Response to Planning Application

From: Arun District Council Leisure & Greenspace

Application ref: M/16/22/PL

Description: Laying out of an 18 hole 72 par golf course, a 9 hole golf course, practice greens and a driving range in front of the A259; construction of a club house with associated golf club facilities; the construction of a maintenance building; parking, new roads and paths; new landscape planting; surface water drainage basins and water storage reservoirs.

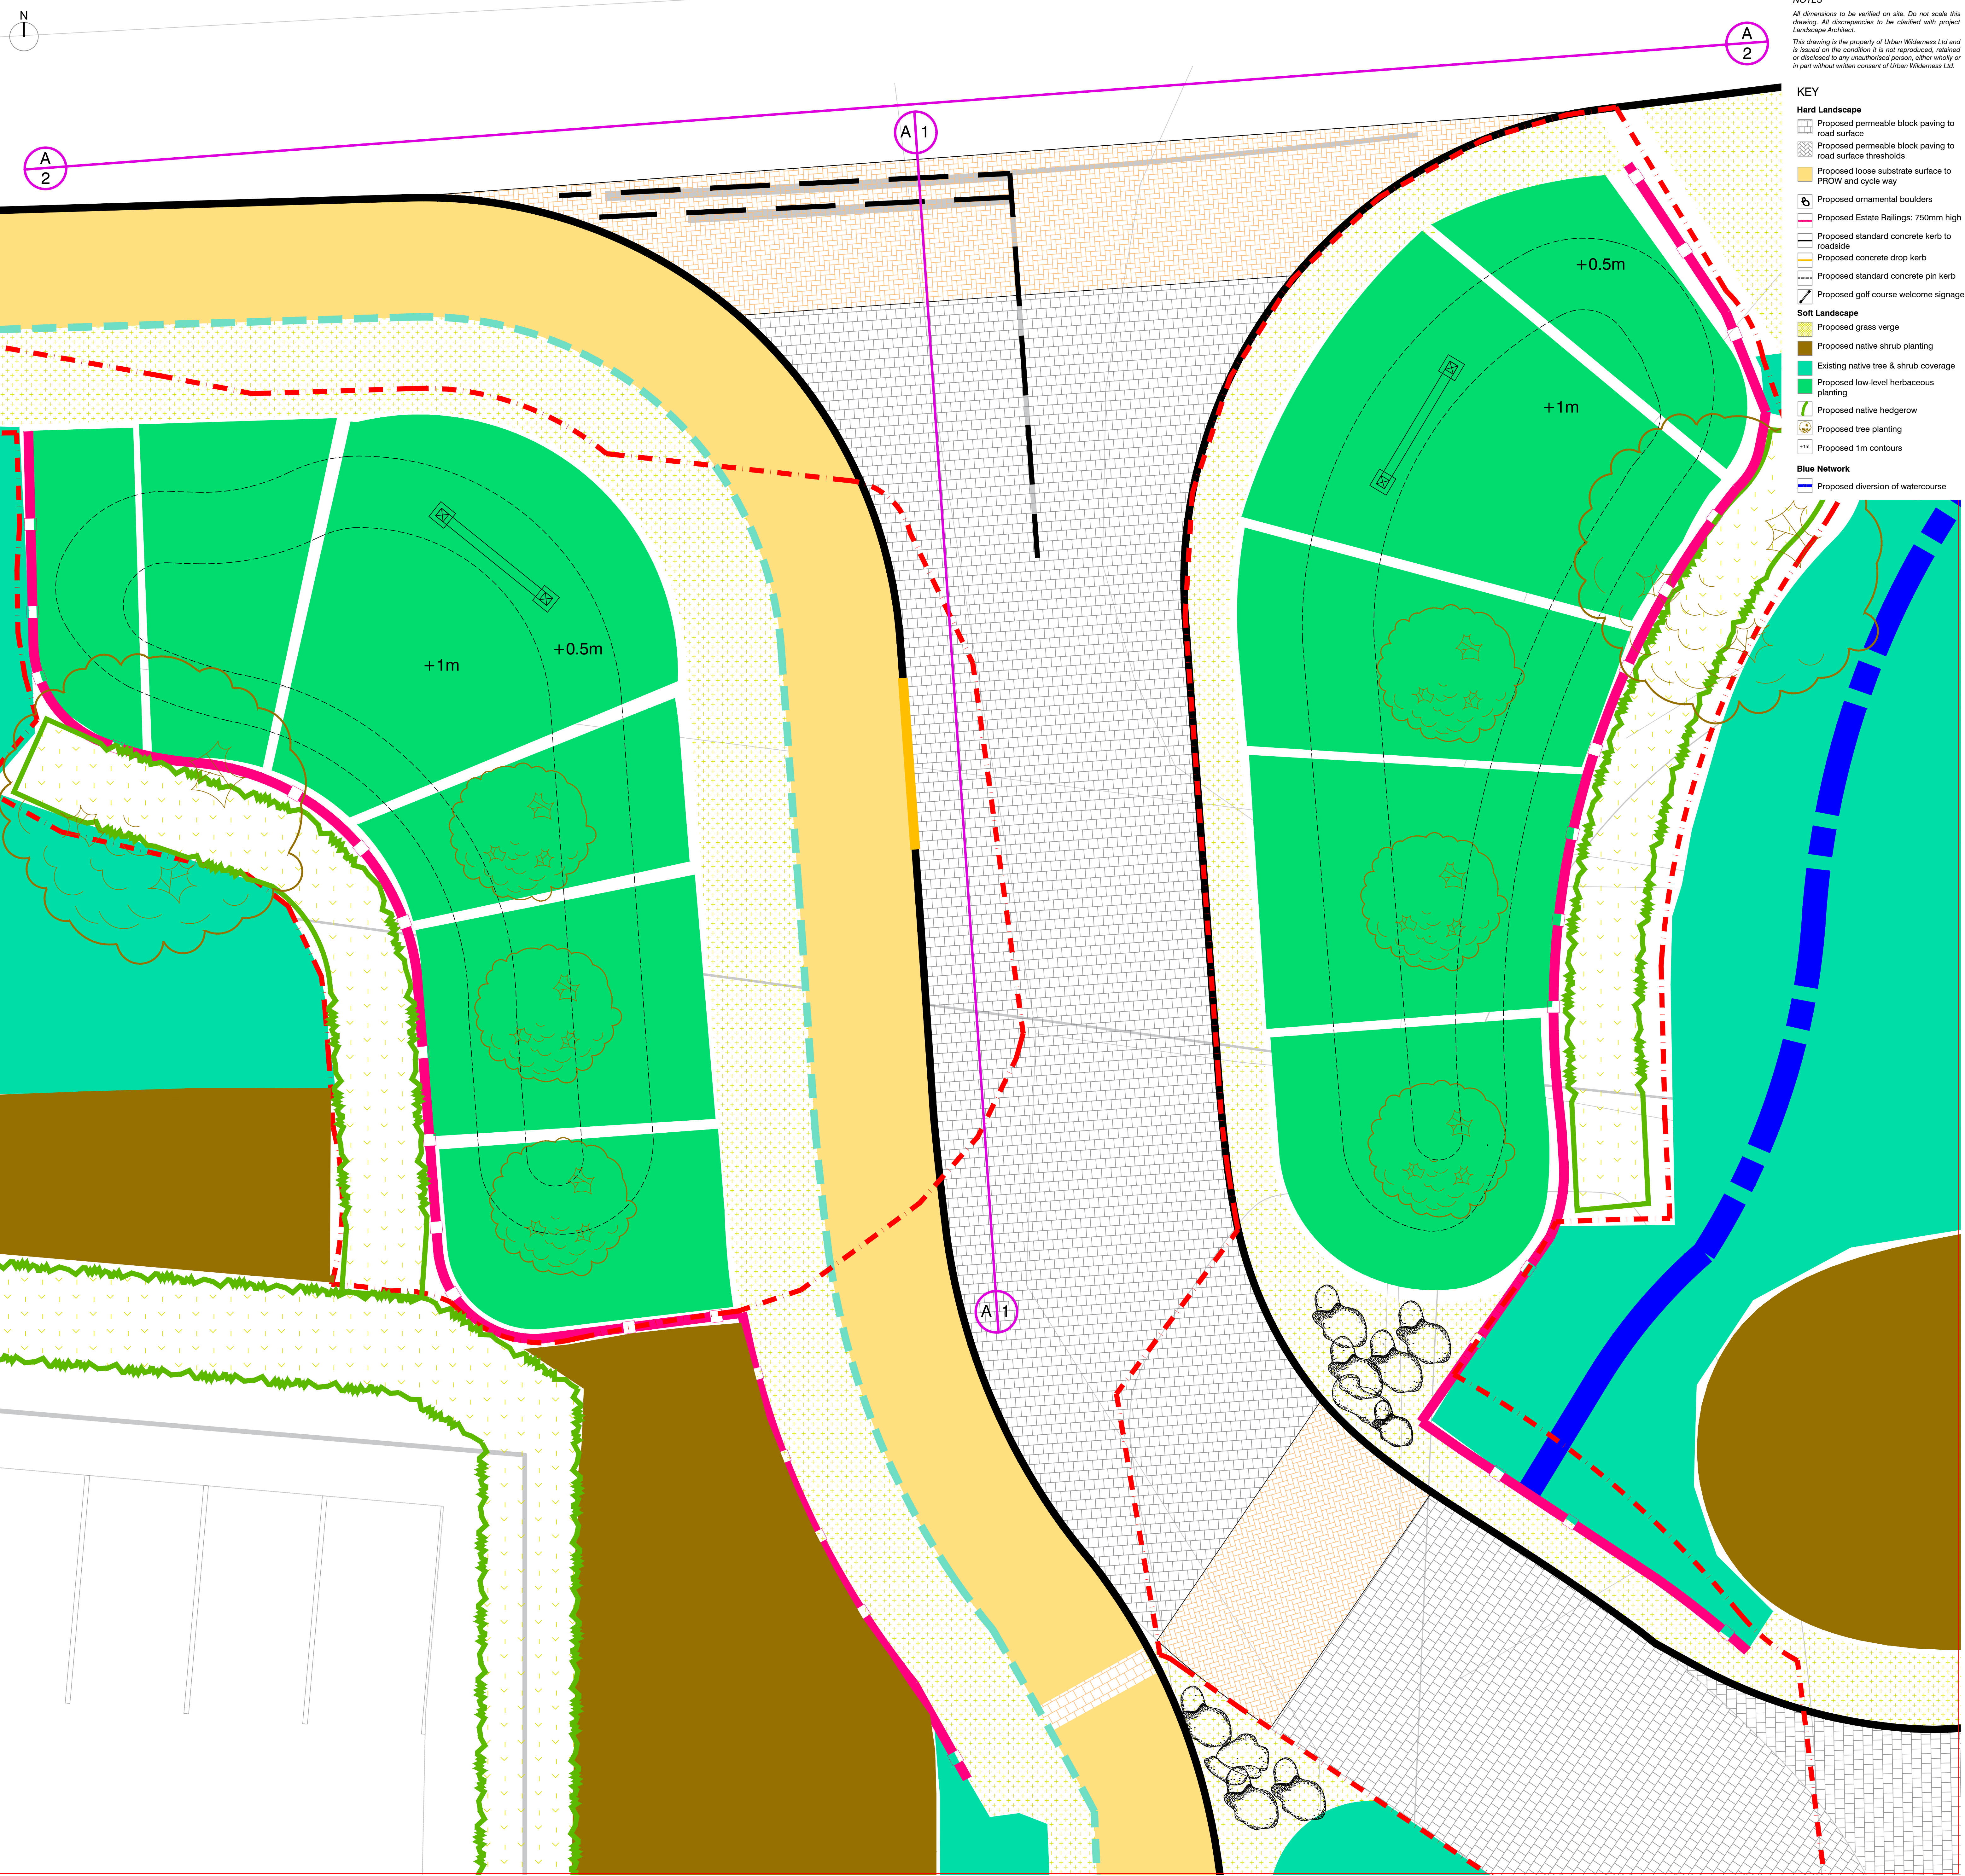
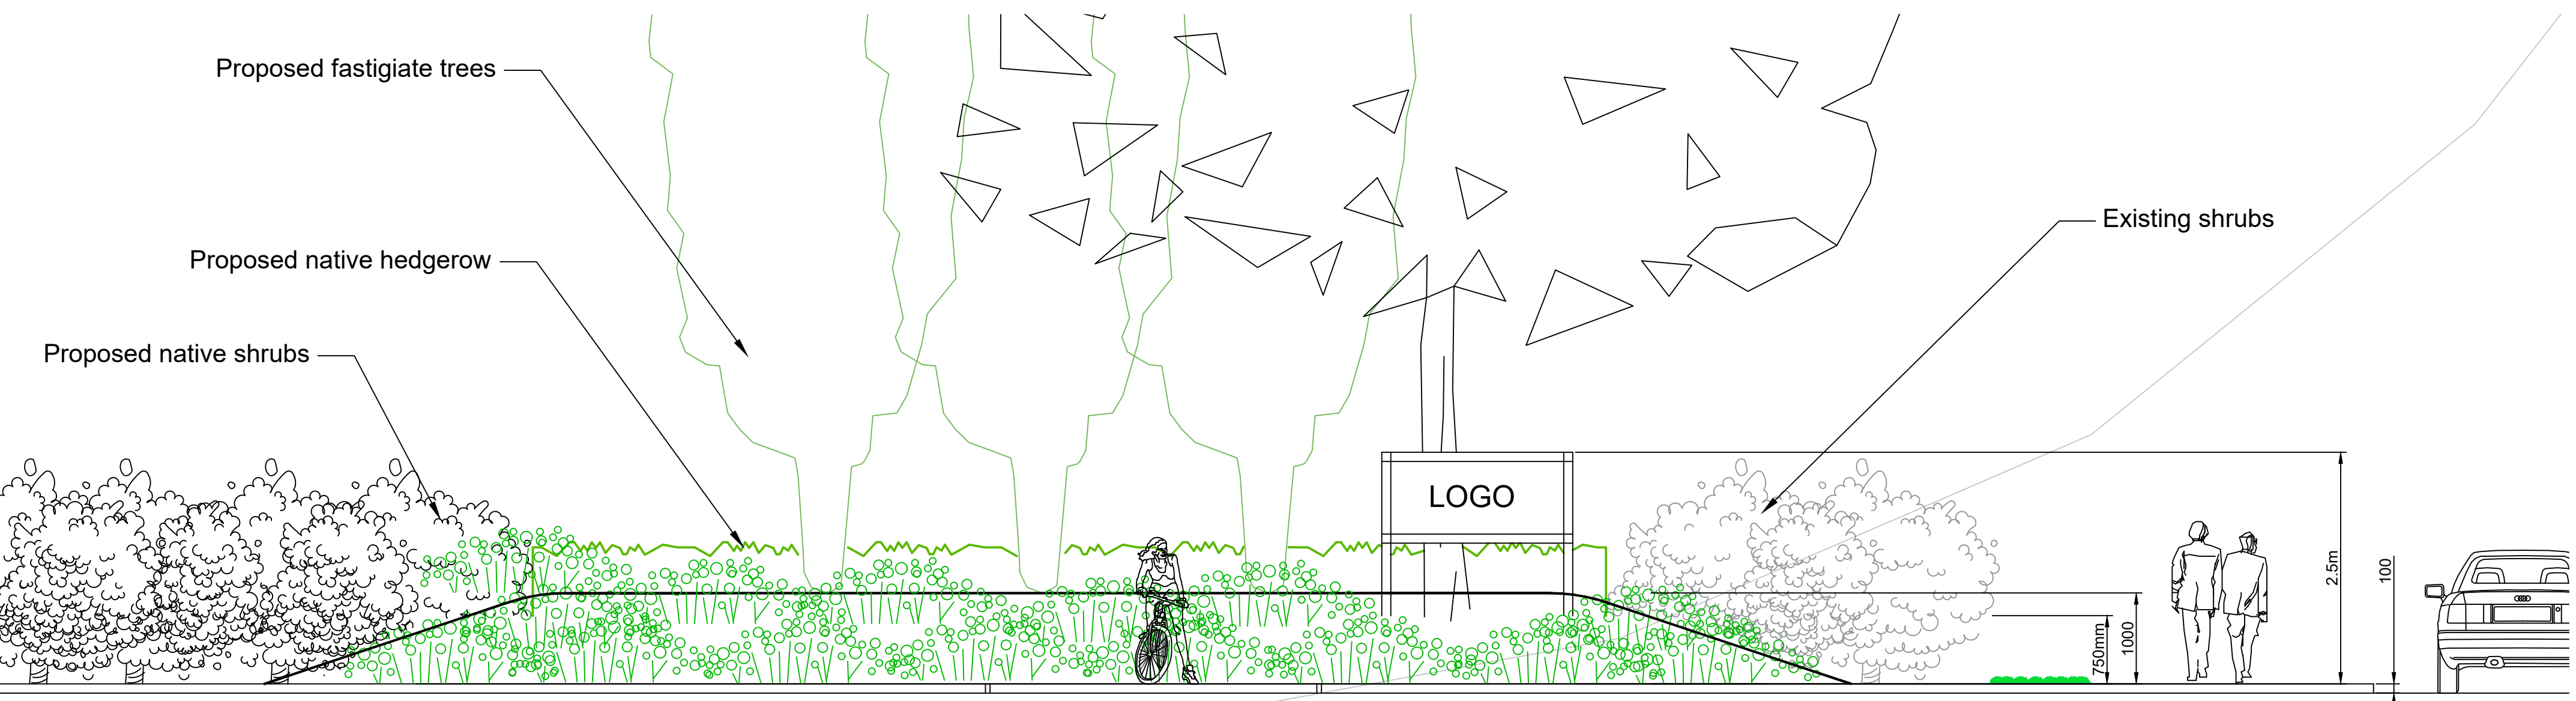
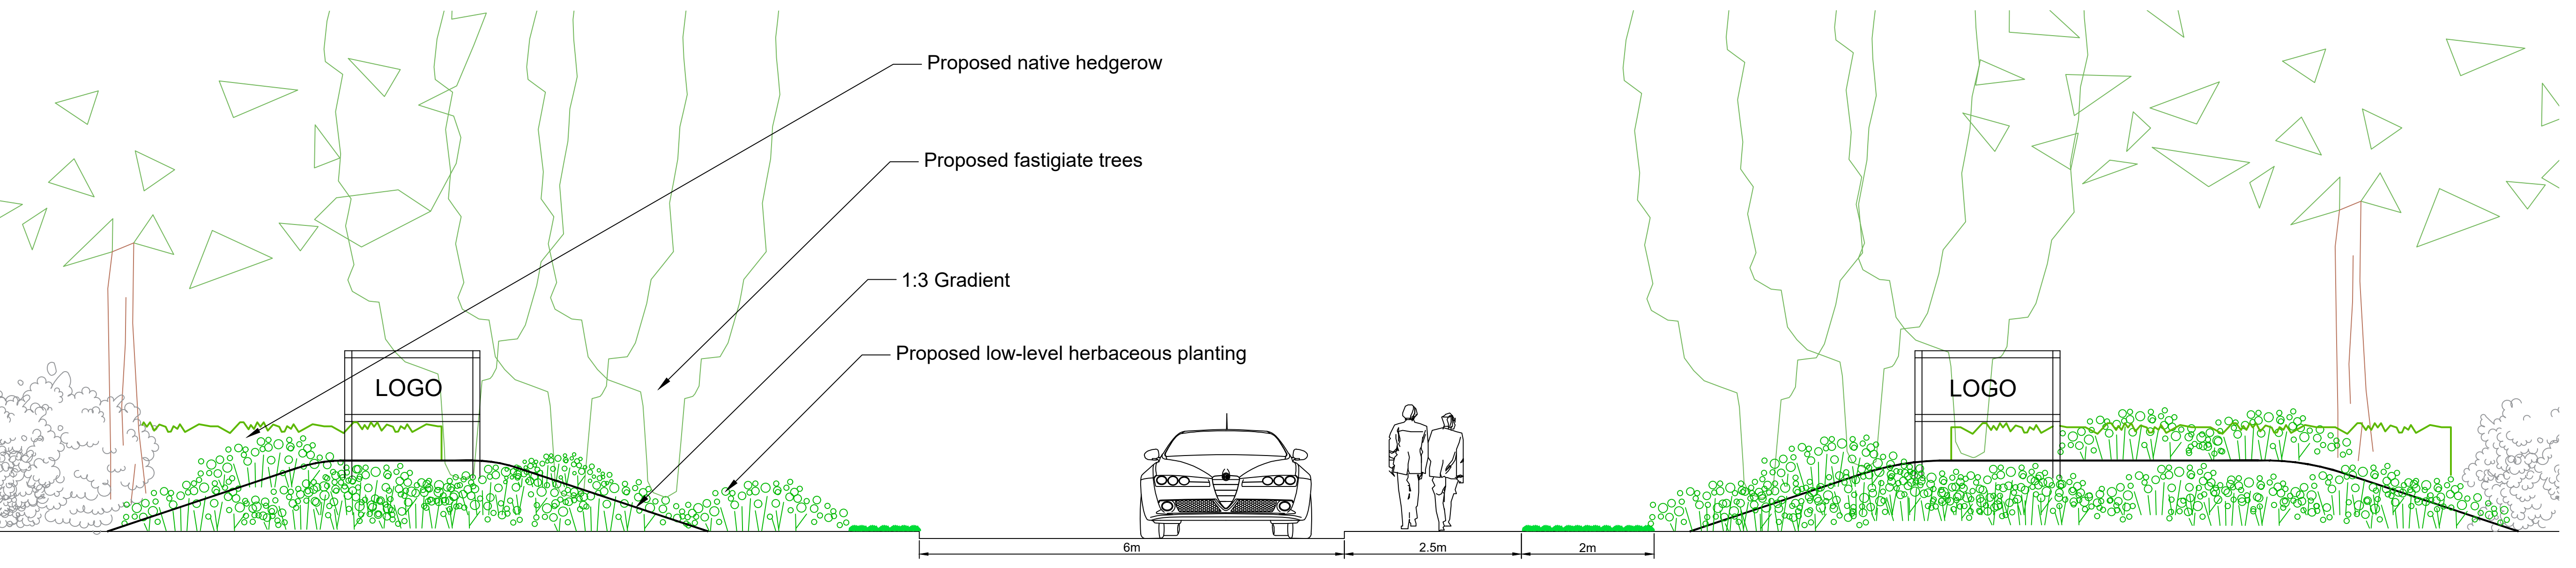
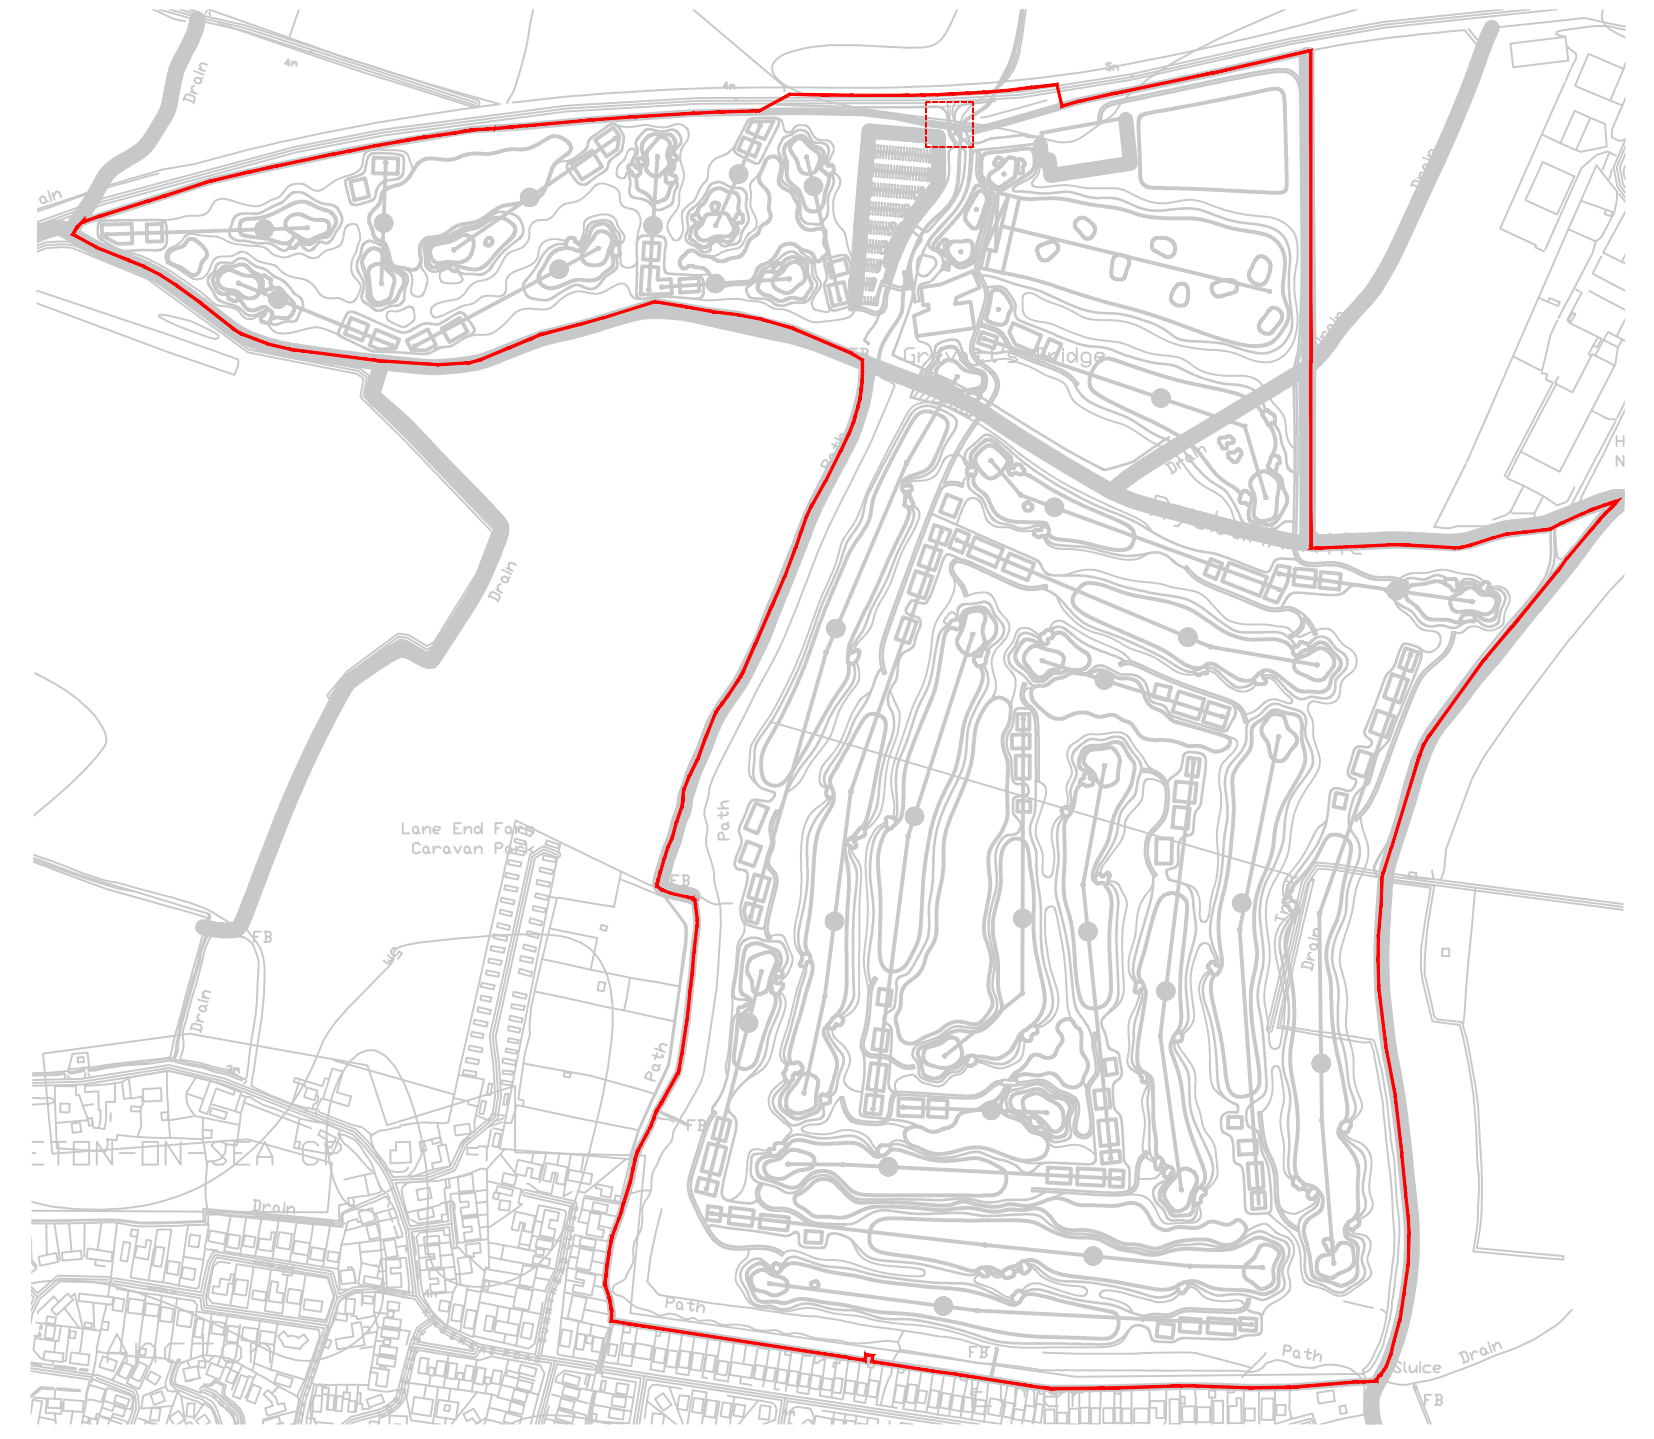
Dwgs: Proposed Access Arrangement – JNY10830-09F has shown amendments to access proposals and vegetation amendments to the visibility spays in this area. Landscape detail will need to be re-considered as a result of these amends however this should not pose any compromise to the setting or the scheme as a whole.
